**WELWYN HATFIELD COUNCIL – DEVELOPMENT CONTROL**  
**DELEGATED REPORT**

<b>APPLICATION No:</b>	<b>S6/2008/778/FP</b>
------------------------	-----------------------

The application seeks full planning permission for demolition of the existing garage and erection of two storey side and rear extension with dormer windows.

Drawn mRn 8504/P/011 b

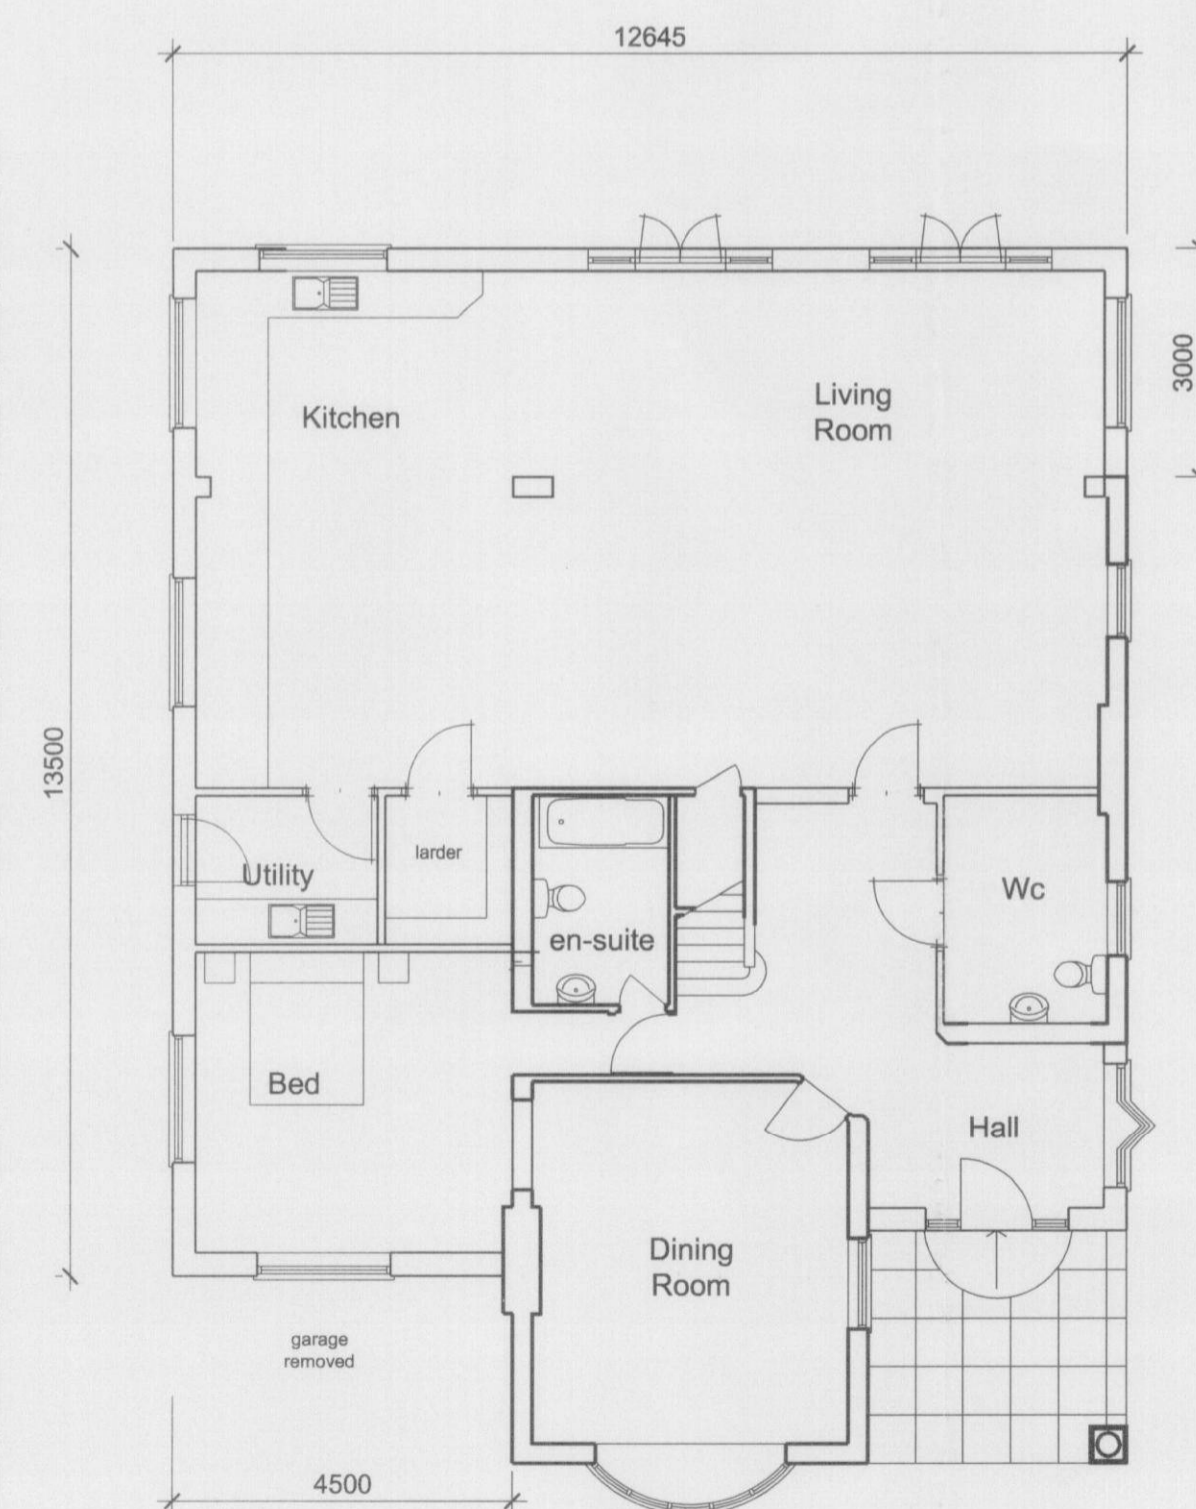
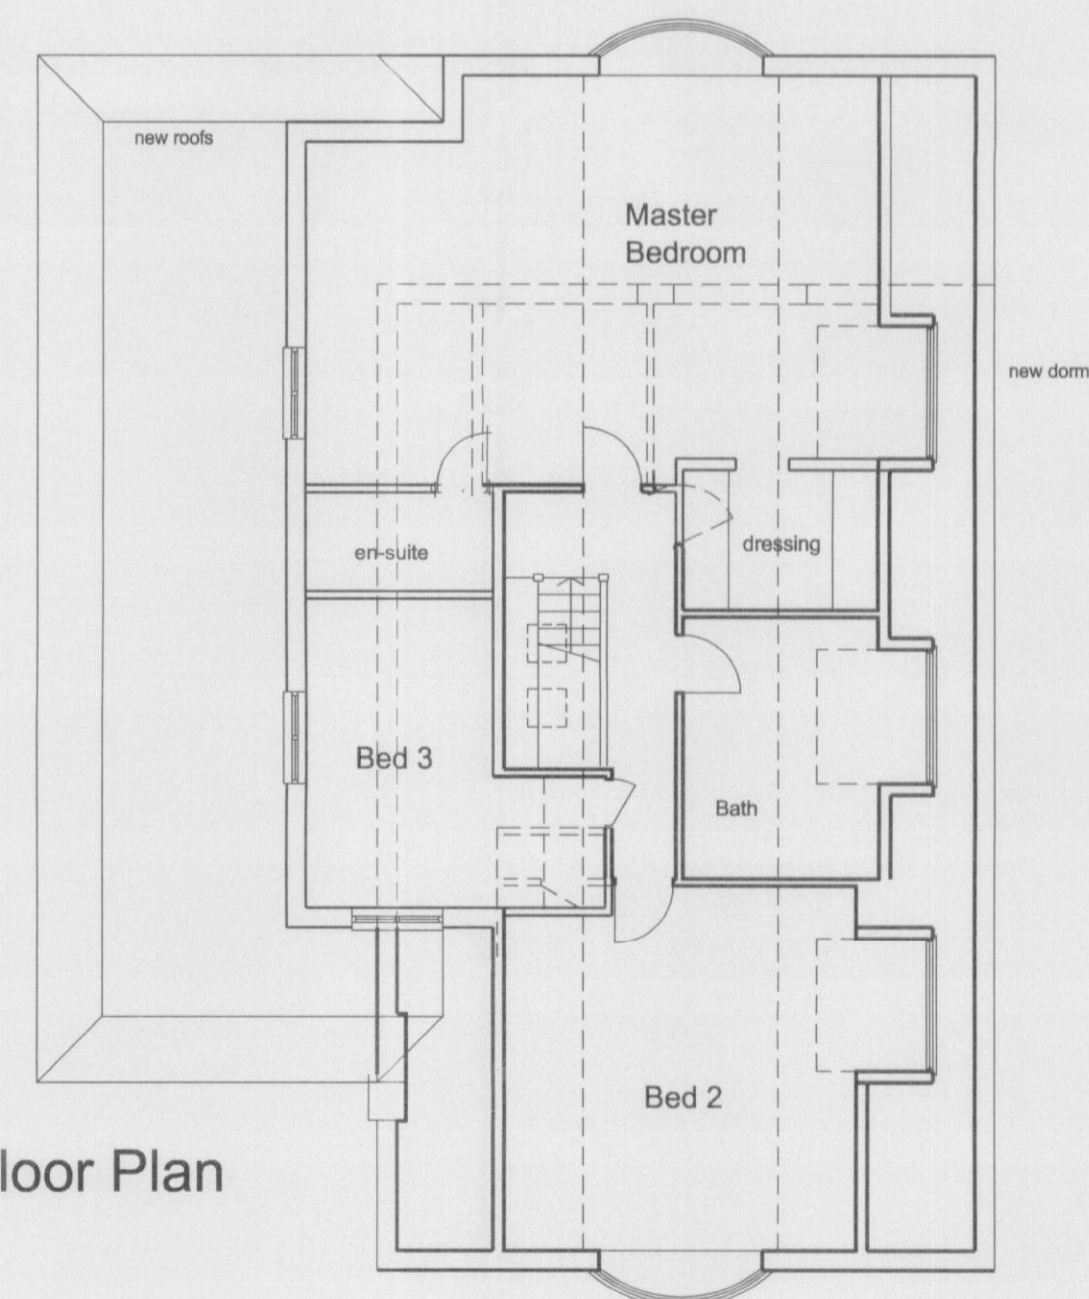
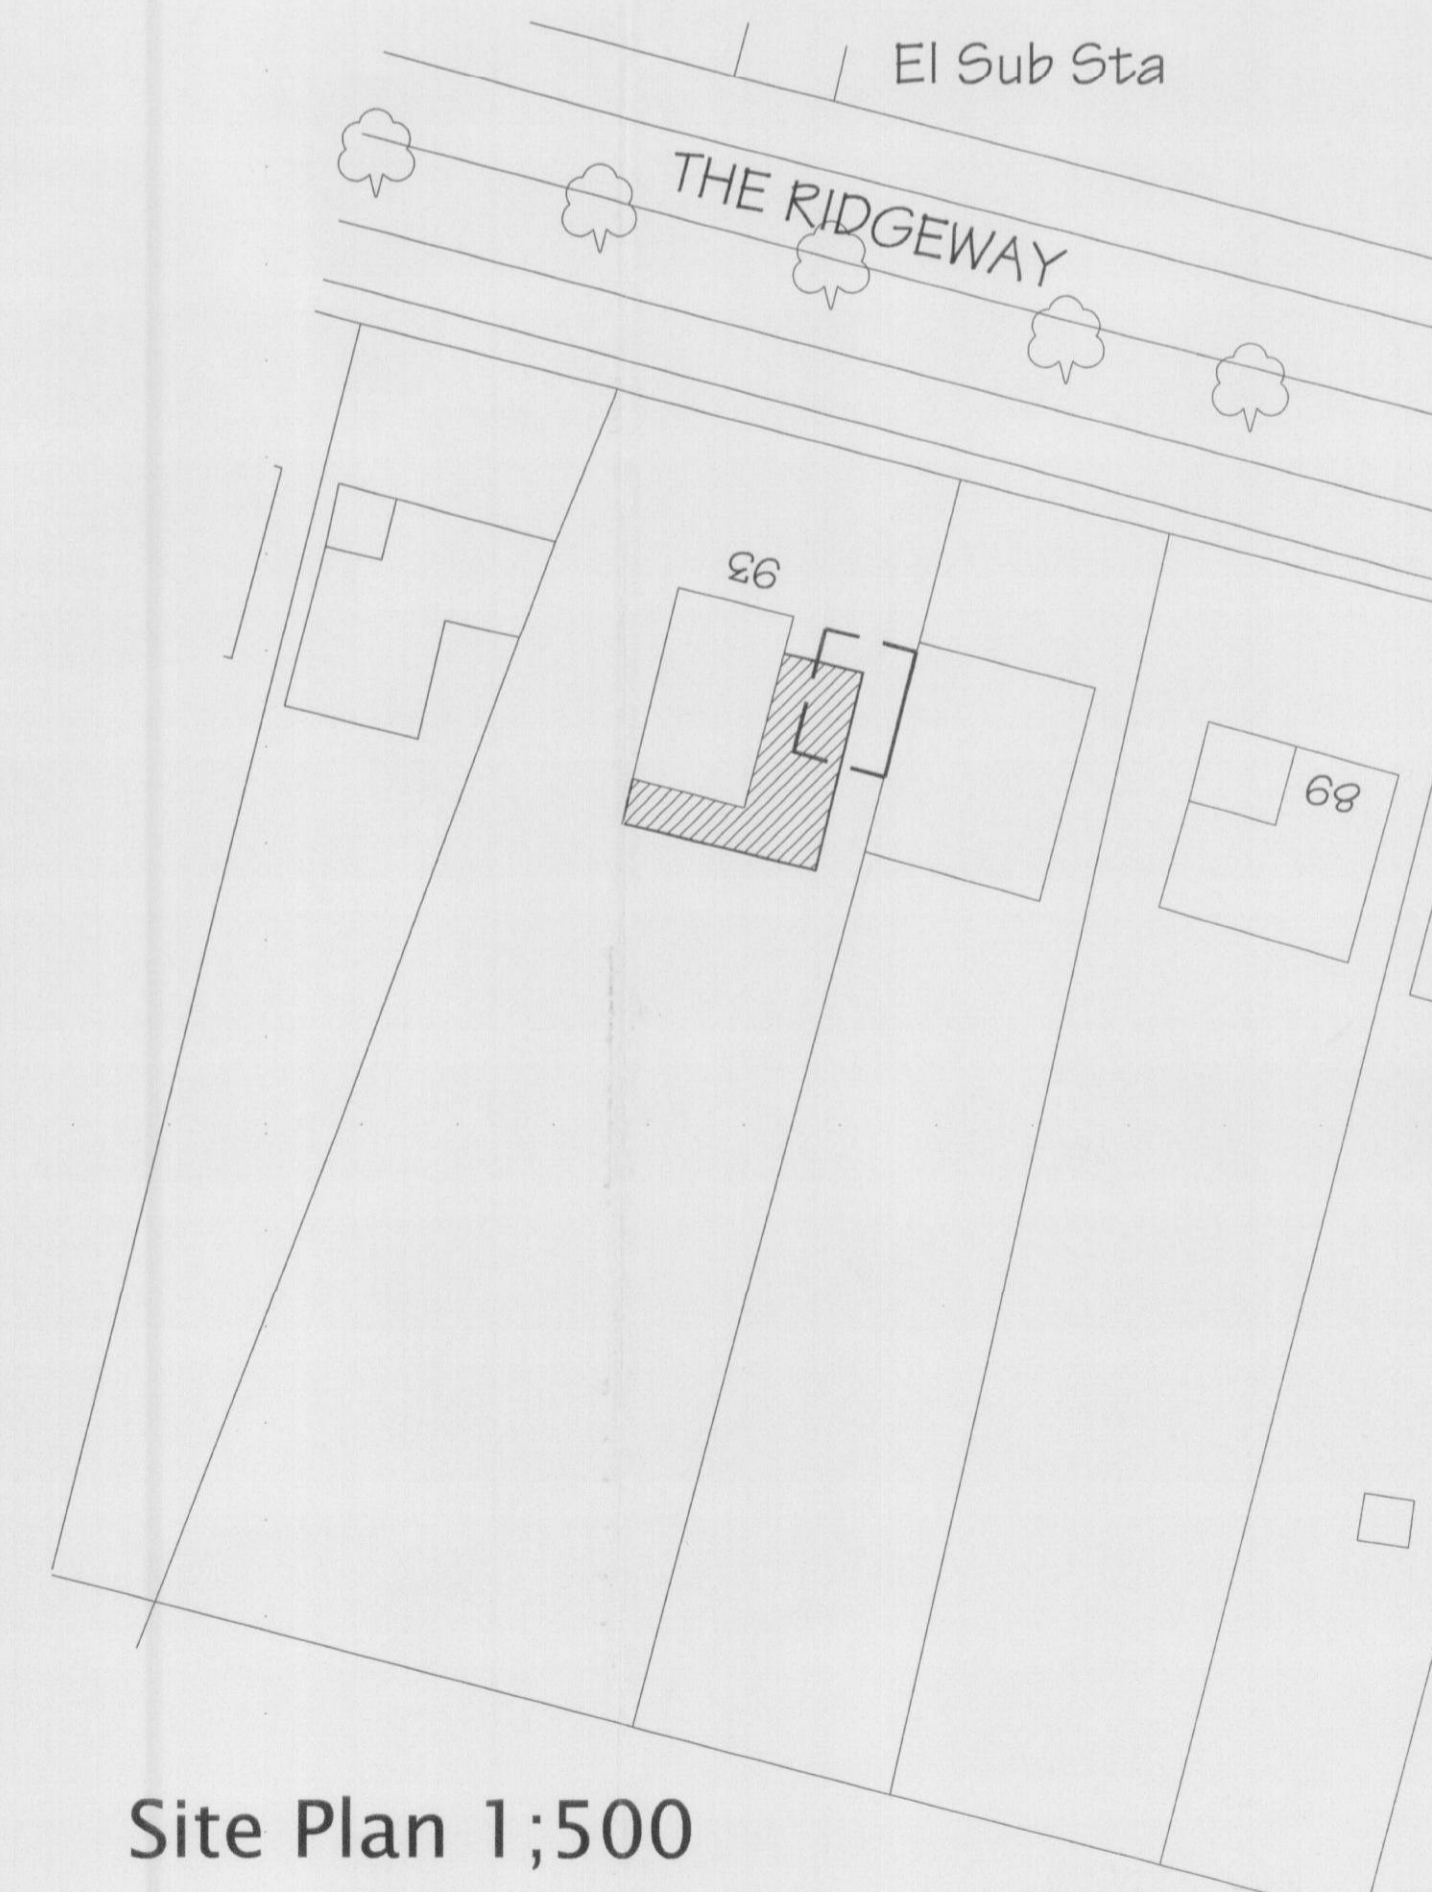
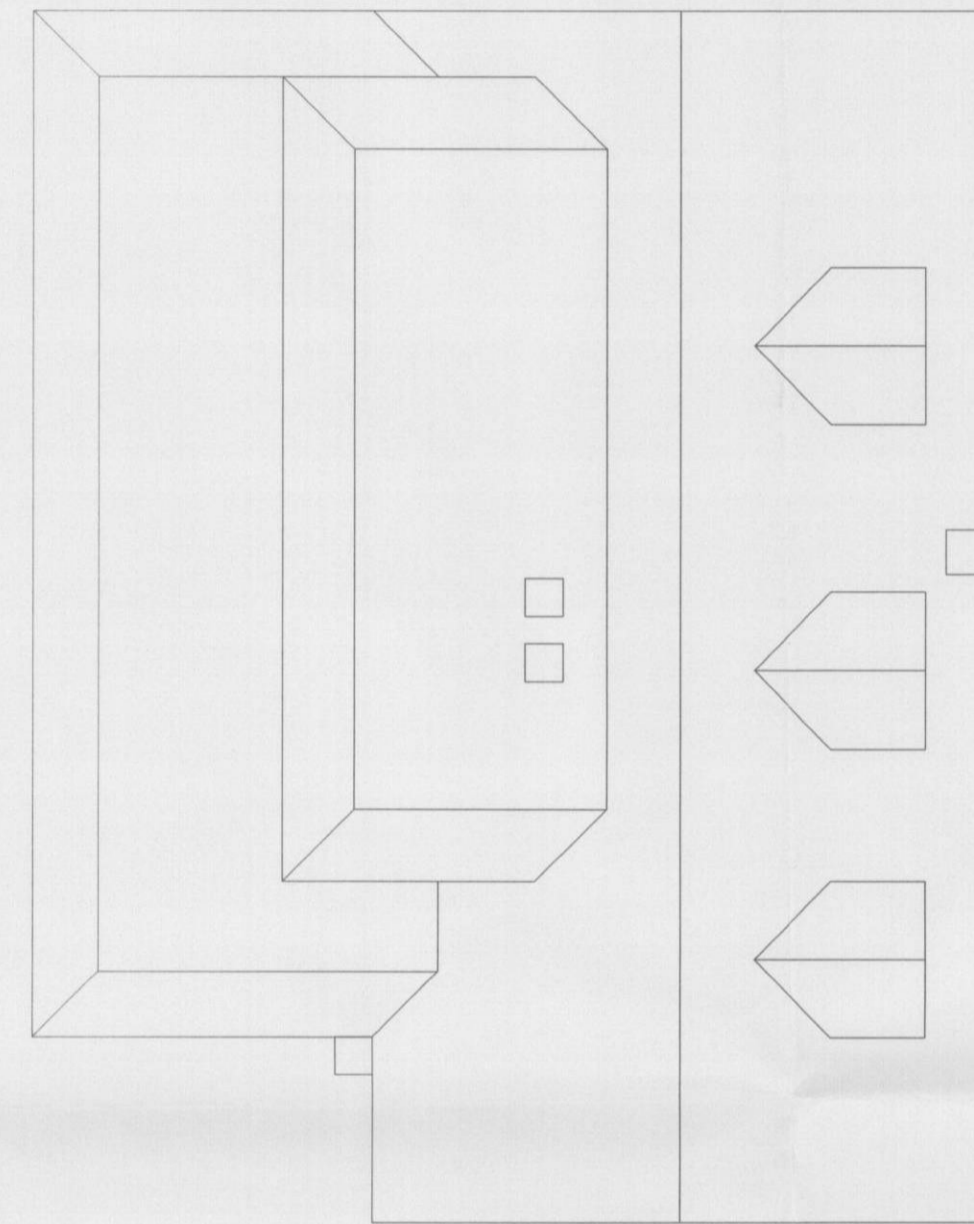
From looking at the figures it is considered that an increase in floorspace of 133 sq.m (79%) and footprint of 85 sq.m (80%) are considered to be disproportionate to the original dwelling particularly at ground floor level. The most recently refused scheme S6/2008/254/FP had a floorspace of 123 sq.m (73%) and footprint of 100 sq.m (94%) and it is considered that the figures for the current scheme are not too dissimilar. Also, it is considered that even taking into account the existing 37 sq.m of floorspace provided by the garage, these figures would be unacceptable in terms of Green Belt policy. Consequently, it is considered that the proposals fail to comply with the advice contained within PPG2 and section (i) of Policy RA3 (Extension to Dwellings in the Green Belt).

However, it is also important to consider the overall visual impact of the extension in relation to its prominence, size, bulk and design on the openness of the Green Belt. It is acknowledged that there is an existing garage on this side elevation, which would be demolished and the proposed side extension would be relocated slightly further to the rear of the site. However, the proposed extension incorporates additional bulk to both the side and rear elevations at ground and first floor level.

The applicant has referred to planning application reference S6/2007/1588/FP, which granted a similar scheme at 85 The Ridgeway. It is acknowledged that there are similarities between each scheme, however there are some notable differences. Firstly, the property at 85 The Ridgeway had a clutter of buildings within 5 metres of the dwelling (including garage and sheds) and these were taken into account with the planning permission. Additionally, there was an existing first floor rear extension granted prior to 1977, which incorporated a veranda at ground floor level and part of the 2007 scheme involved the infill of this existing floorspace. Also, when comparing each scheme it was noted that the permitted scheme at 85 The Ridgeway had a maximum depth of 9.6 metres and was set back from the highway by 5.4 metres whereas the proposed scheme at 93 The Ridgeway has a maximum depth of 10.3 metres and is set back from the highway by 4.7 metres and proposed an additional dormer window in the side (west) elevation. It is considered that these variations represent a bulkier and more prominent feature.

Consequently, it is considered that the proposed extensions would have a greater visual impact in terms of prominence, size, bulk and design on the openness of the Green Belt and as such fails to comply with PPG2 and Section (ii) of Policy RA3 contained within the Welwyn Hatfield District Plan 2005.

The proposed extension would involve demolition of the existing detached flat roof garage and creation of a ground floor wrap around extension with hipped roof design and a first floor side extension with hipped roof design, which are considered to be appropriately designed and relate to the surrounding properties. Additionally, the double storey rear extension would maintain the gabled end and pitched roof design of the original dwelling, which is considered to relate adequately to the original architectural features of the dwelling.

The roofline of the proposed side extension has been set slightly lower than the ridgeline of the property and is level with the positioning of the existing dormer window on the side (west) elevation. This is considered to maintain balance and symmetry from the front elevation.

The bay window to the rear and gabled dormer window to the side (west) elevation would respect the original architectural features and would not be detrimental to the character of the dwelling or street scene and as such complies with Policies D1 and D2 of the Welwyn Hatfield District Plan 2005.

It is also proposed to create a further dormer window within the side (west) elevation. This would maintain the existing design and proportions to the existing windows and would be placed at a similar height above ground level within the roofline. The proposed dormer window complies with Section 5.1 vi of the Supplementary Design Guidance as it is located below the ridge height, in proportion to the existing fenestration and set in by at least 1m from the flank walls. It has also been designed to emulate the original chalet design of the bungalow and therefore would not detract from the character of the house or street scene. This complies with Policy D1 of the Welwyn Hatfield District Plan 2005.

The additional dormer windows within the side elevations have the potential to create further overlooking to adjacent properties. Consequently, a condition could be attached to obscure windows as those situated within the eastern elevation provide for an ensuite bathroom and a secondary bedroom window and a new dormer within the west elevation creates a secondary bedroom window . This complies with Policy D1 and the material contained within the Supplementary Design Guidance 2005.

The proposed single storey side and two storey side and rear extensions with new dormer windows would result in a disproportionate increase in the size of the dwelling to have an adverse visual impact (in terms of its prominence, size, bulk and design) on the character and openness of the Green Belt. This fail to comply with the advice contained within PPG2 and Policy RA3 of the Welwyn Hatfield District Plan 2005.

1. The proposal by virtue of the size, bulk, scale and design would result in a disproportionate addition over and above the size of the original dwelling and therefore represent inappropriate development within the Green Belt. The applicant has failed to demonstrate to the satisfaction of the Local Planning Authority any very special circumstances exist to outweigh the harm caused by reason of its inappropriateness. In addition, the proposal by virtue of its siting, design and bulk would have a detrimental impact on the character and openness of this part of the Green Belt and the visual interest of its surroundings. The proposal is therefore contrary to the advice contained within PPG2 and Policies RA3 and RA10 of the Welwyn Hatfield District Plan 2005.
